REVIEW RESPONSE

DATE: 5/31/2022

PROJECT NAME: AMIGA PIER

RESPONSE TO: SHL21-041 / SEP21-026 REQUEST FOR INFORMATION

SHEET
A4.0

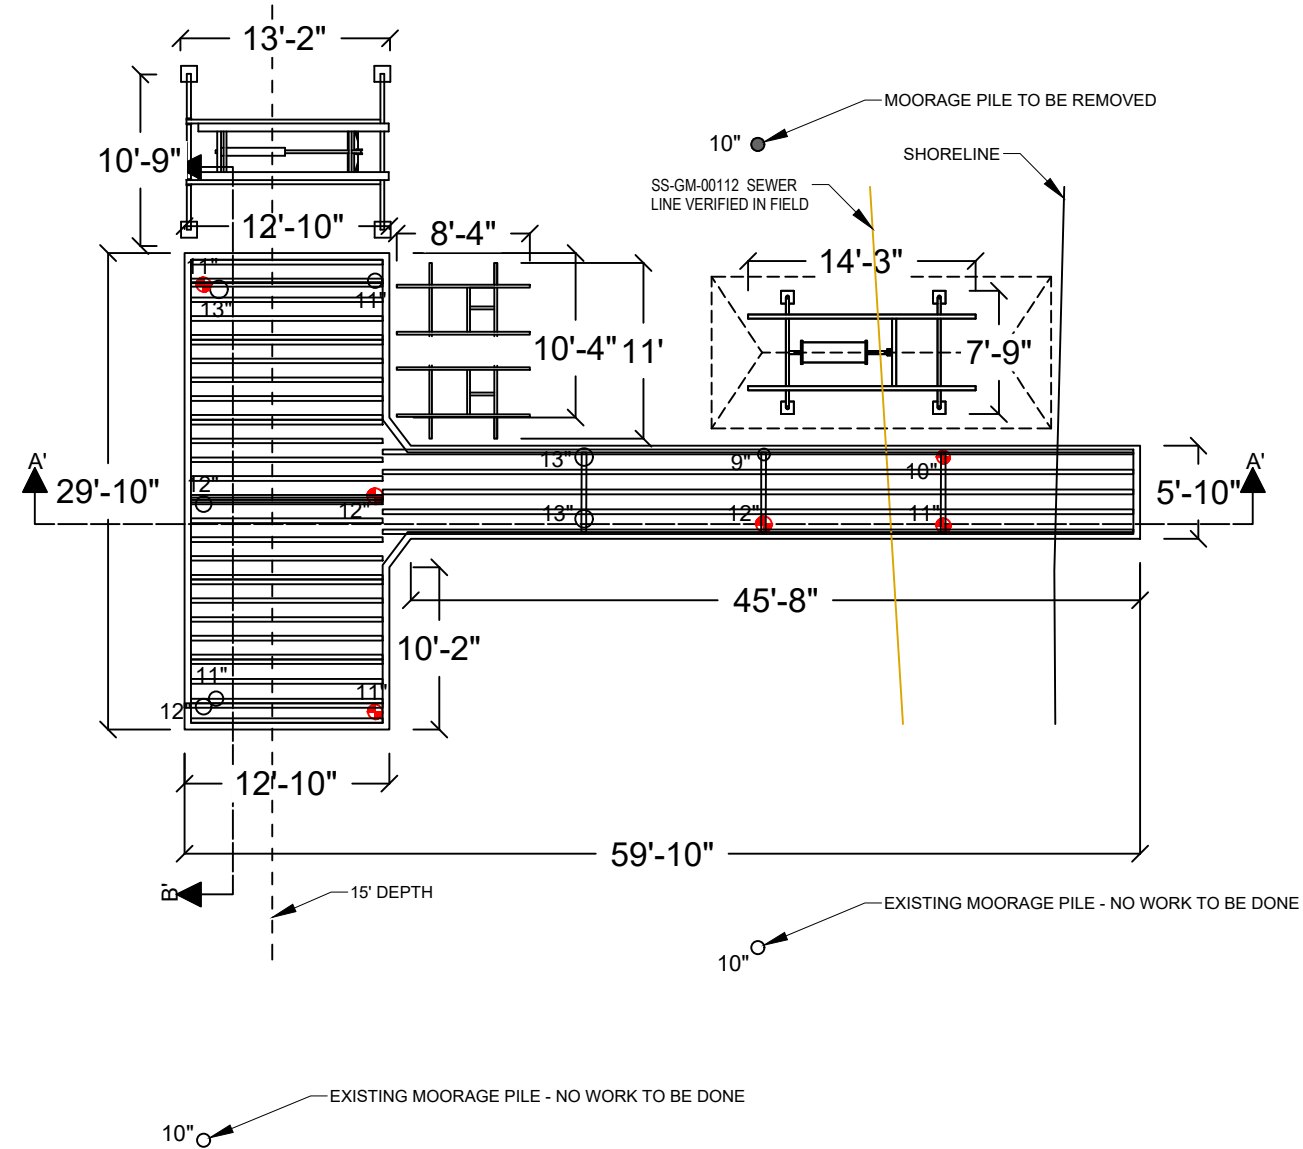
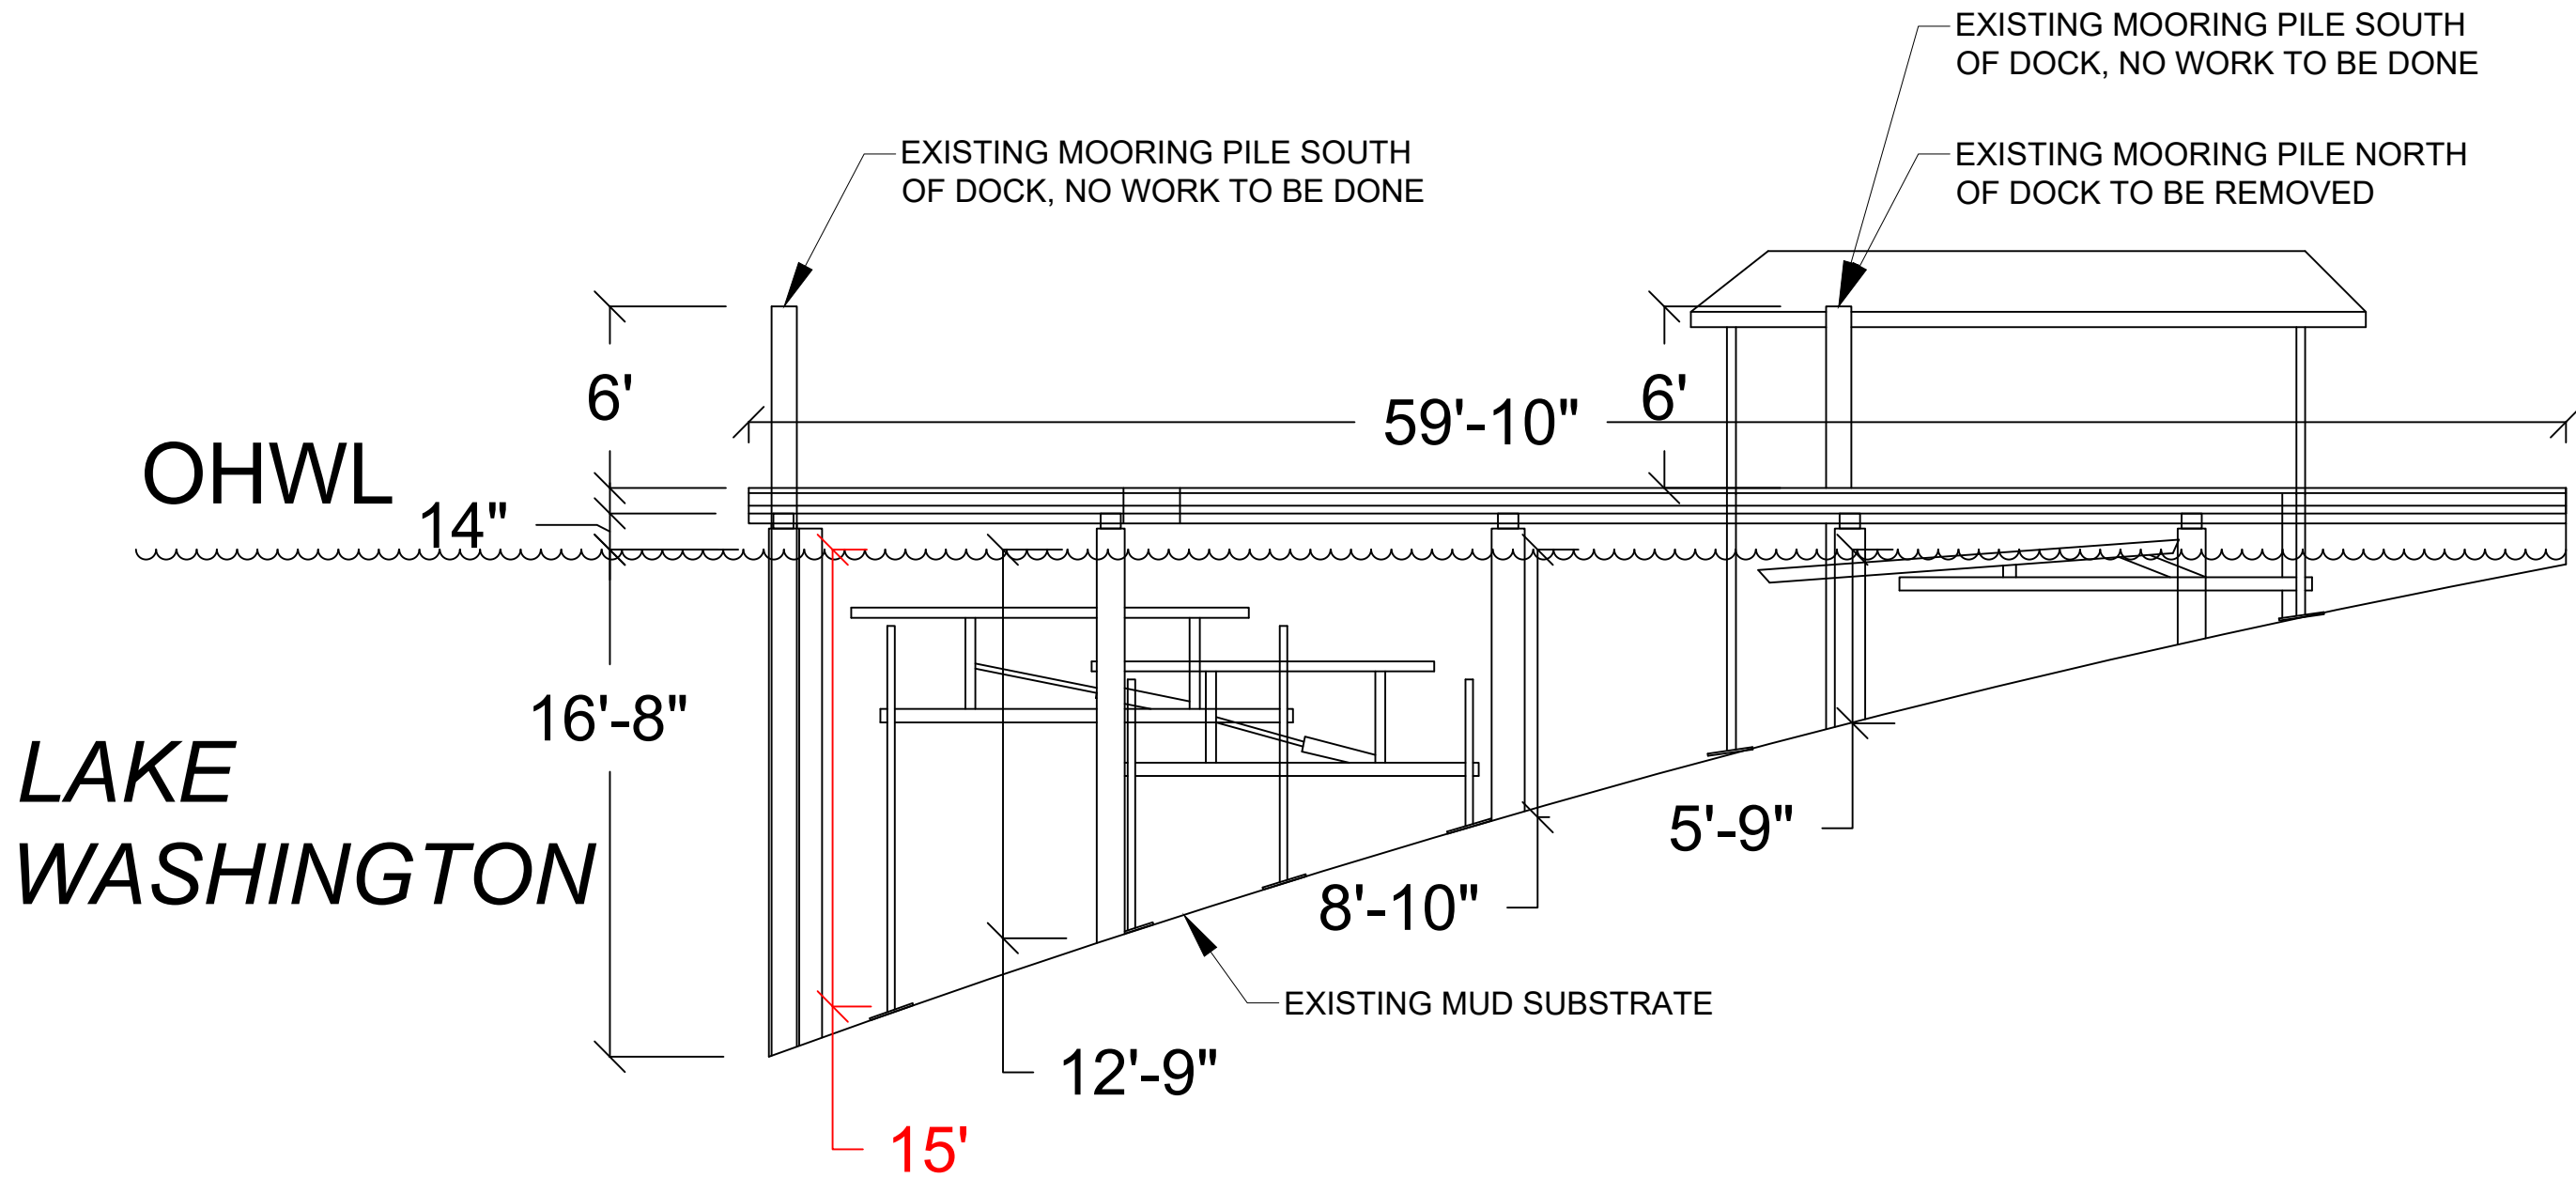
4. MICC 19.13.050(F)(2)(ix) states that the structural repair, which may include replacement of framing elements (including but not limited to, stringers, piles, pile caps, and attachment brackets), of moorage facilities that results in the repair of more than 50% of the structure's framing elements within a 5-year period shall comply with the following requirements:

a. 100% of the decking area of the pier, dock, and any platform lifts must be fully grated with materials that allow a minimum of 40% light transmittance.

b. The height above the OHWM for moorage facilities, except floats, shall be a minimum of 1.5 feet and a maximum of 5 feet.

c. An existing moorage facility that is 5 feet wide or more within 30 feet waterward from the OHWM shall be replaced or repaired with a moorage facility that complies with the width of moorage facilities standards listed in MICC 19.13.050(D), Table D.

Please provide an accounting of all the framing elements, including, but not limited to, stringers, piles, pile caps, and attachment brackets, that are proposed to be repaired or replaced as a part of this proposal. Please also demonstrate that the total number of framing elements to be replaced does not exceed the 50% threshold of MICC 19.13.050(F)(2)(ix) is being exceeded. If the 50% threshold is being exceeded, please provide revised plans that show compliance with MICC 19.13.050(F)(2)(ix)(a) through (c).

See page A4.0 of updated plan set. We do not meet the 50% repair threshold.

See page A4.0 of updated plan set. We do not meet the 50% repair threshold.

See page A4.0 of updated plan set. We do not meet the 50% repair threshold.

See page A4.0 of updated plan set. We do not meet the 50% repair threshold.

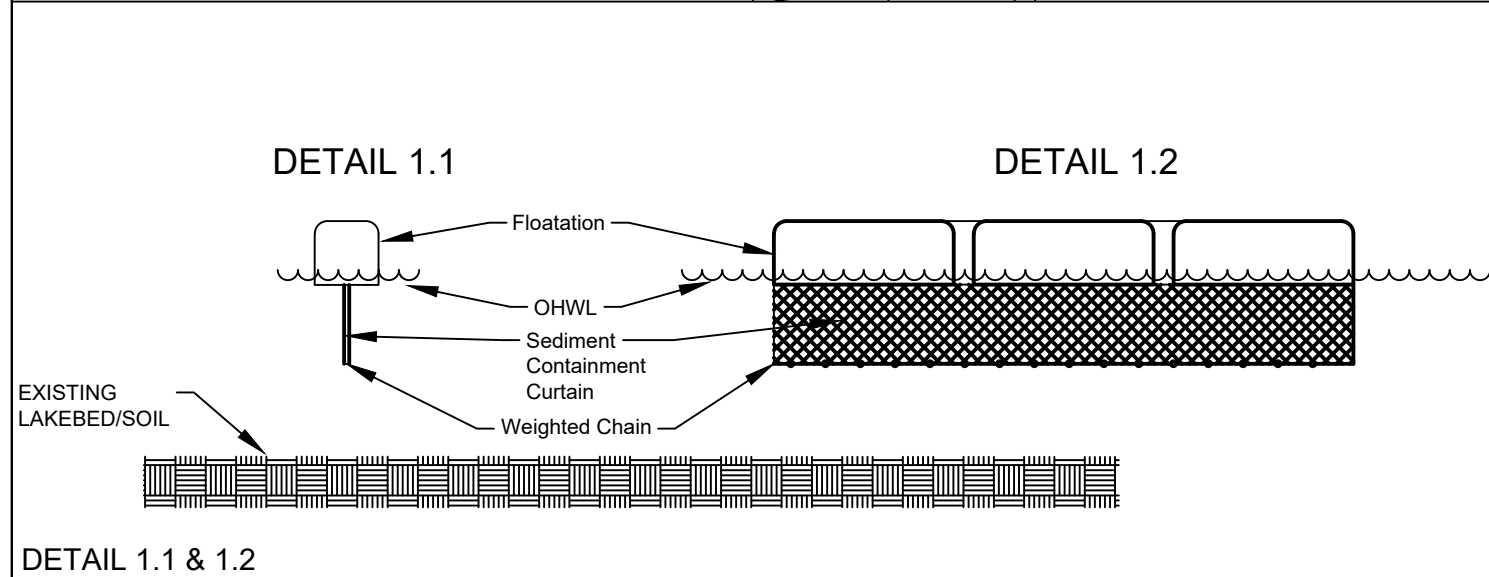
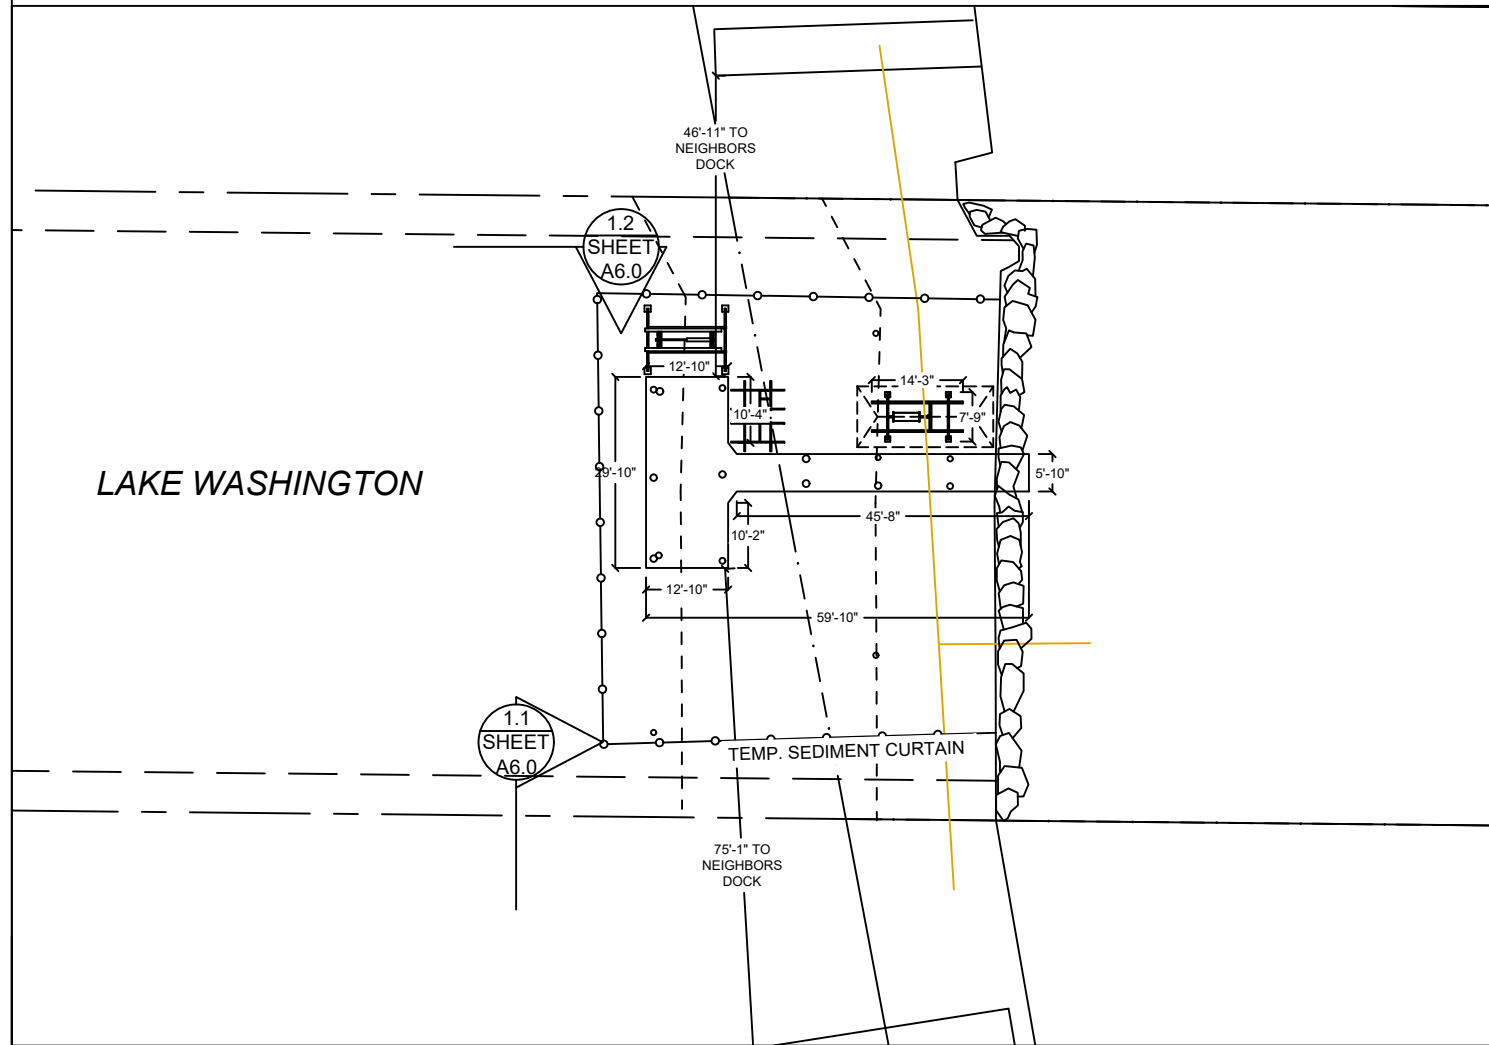
2. Please provide the following information on the pier elevations:

a. Please show all moorage piles on the pier elevation. Please also show the heights of the piles above the OHWM on the elevation.

Please see Sheet A5.0 of updated plan set.
